# J.J. MARINO & ASSOCIATES

**RE: DWYER'S REDEVELOPMENT  
CROWN STREET, WOLLONGONG  
PRELIMINARY DESIGN PHILOSOPHY**

At your request, we have reviewed the architectural concept plans for the purpose of assessing whether a feasible structural scheme can be designed and constructed for the proposed development.

PROJECT: 07-104 REDEVELOPMENT OF THE OLD BANK BUILDING FOR REDEVELOPMENT
DATE: 20-08-07
SCALE: AS SHOWN

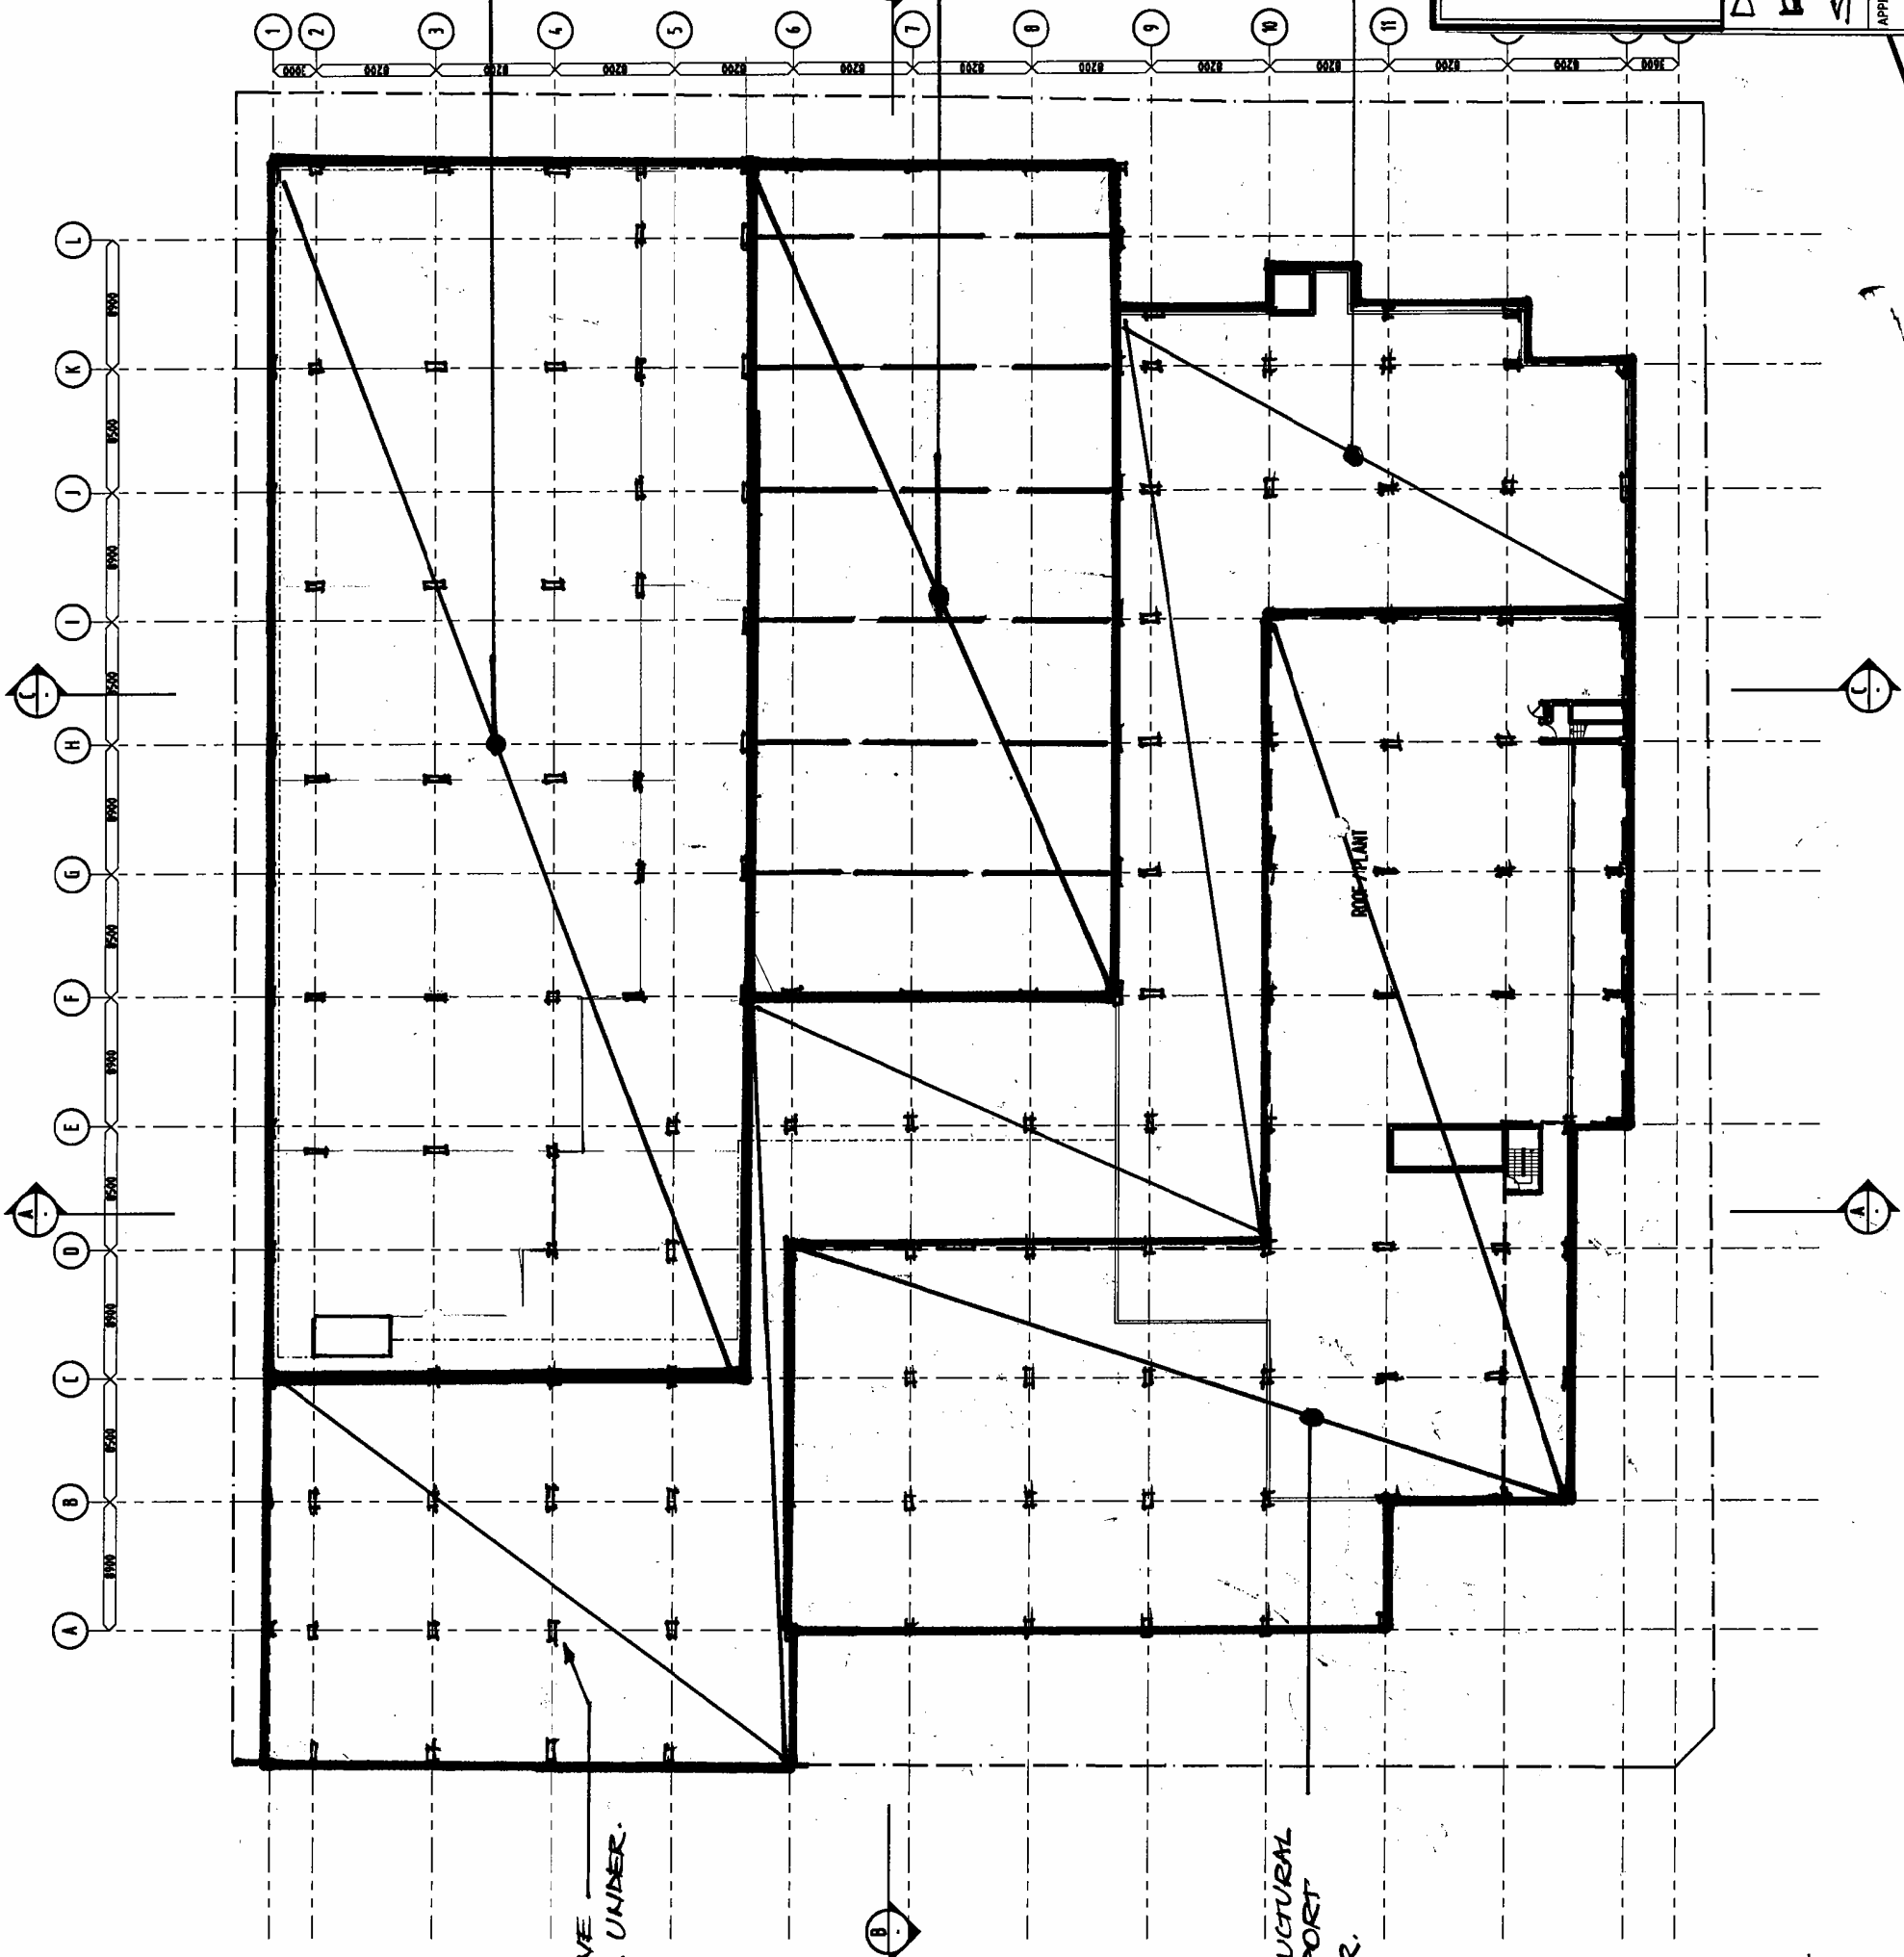
- The proposed layout of the residential towers above the Roof level appears suitable for a system such as "Ritek" or equivalent. Our preliminary load rundown calculations have been based on the adoption of such a system, leading to the structural depths for the transfer at Roof Level.

- The remaining roof level was assumed to be trafficable also.
- All structural depths / zones noted are based on post-tensioned concrete design, with the exception of the roof over the cinema zones. Due to the clear spans involved over the cinemas, a steel framed system with a concrete slab on structural formwork was deemed to be the more appropriate solution.
